Application by Morgan Offshore Wind Limited and Morecambe Offshore Windfarm Limited for an order granting development consent for the Morgan and Morecambe Offshore Wind Farms Transmission Assets

Issue specific hearing 2 Wednesday 30th July 2025

Comments and issues with

- General Matters (Construction Timetable)
- Transport

Figure 1.1: Highway network overview

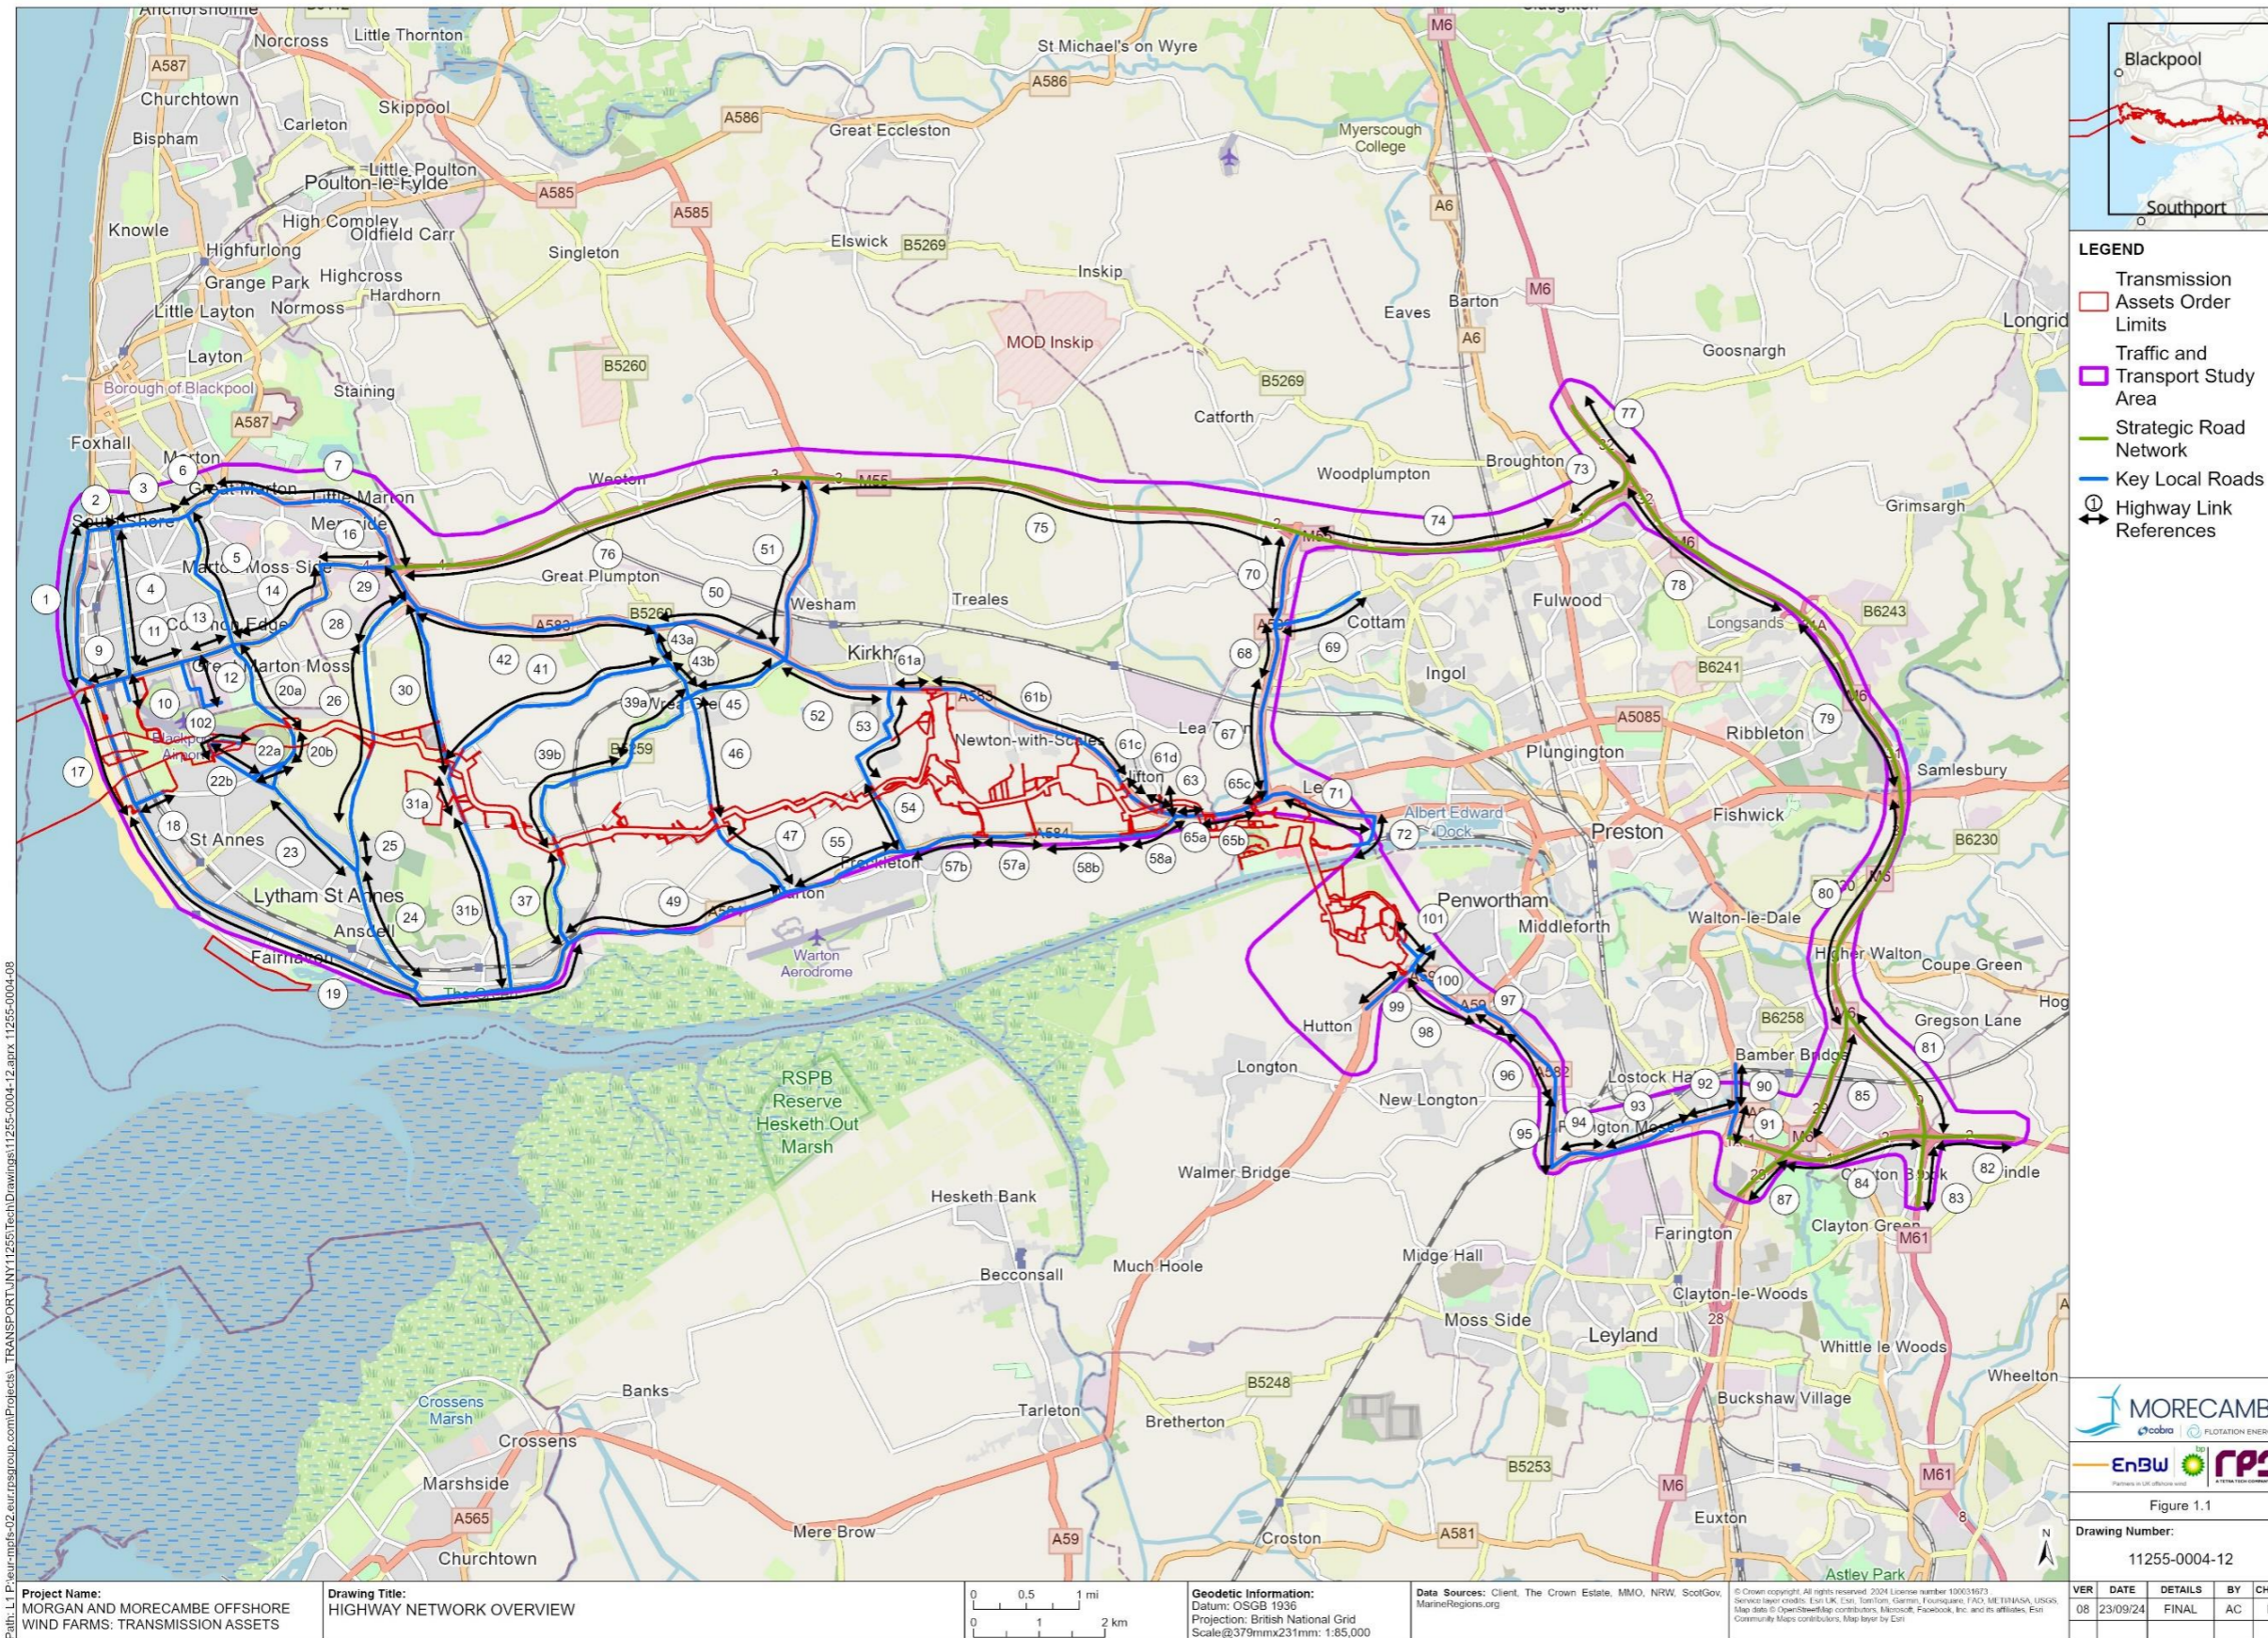
Last year the applicant performed and documented a Fylde coast traffic study. They separated the roads network into over 100 links, a link being a stretch of road between junctions. This comprehensive plan included an assessment of the sensitivity of each link to the use by the proposed HGV movements.

We assume this information subsequently was used to inform the applicant in their choice of routes as evidenced by the diagram in Appendix A page 40 of document Outline Construction Traffic Management Plan [REP2-016].

But the choice of routes must have also been informed by other criteria, what were these? When the choice of routes to a particular construction access point have the same sensitivity in the above study, how was the choice made?

For local people with a deep knowledge of the area the choice of routes to the substations and cable route areas are understandable, except for 2 of the routes.

We would request that the ExA ask the applicant to explain the reasoning behind the choice of two of the routes

The yellow route through Wrea Green to Bryning Lane Links 43&45&46 chosen for access to A34/35 Bryning Lane rather than southern link 47 from A584. (Both of the links had the same sensitivity)

The green route Link 41 along Ballam Road to the cluster of access points at the junction of Ballam and Peel Roads rather than the shorter Link 30 route direct from M55 J4 at Blackpool, which uses a much shorter distance on lower classification roads. (Both of the links had the same sensitivity)
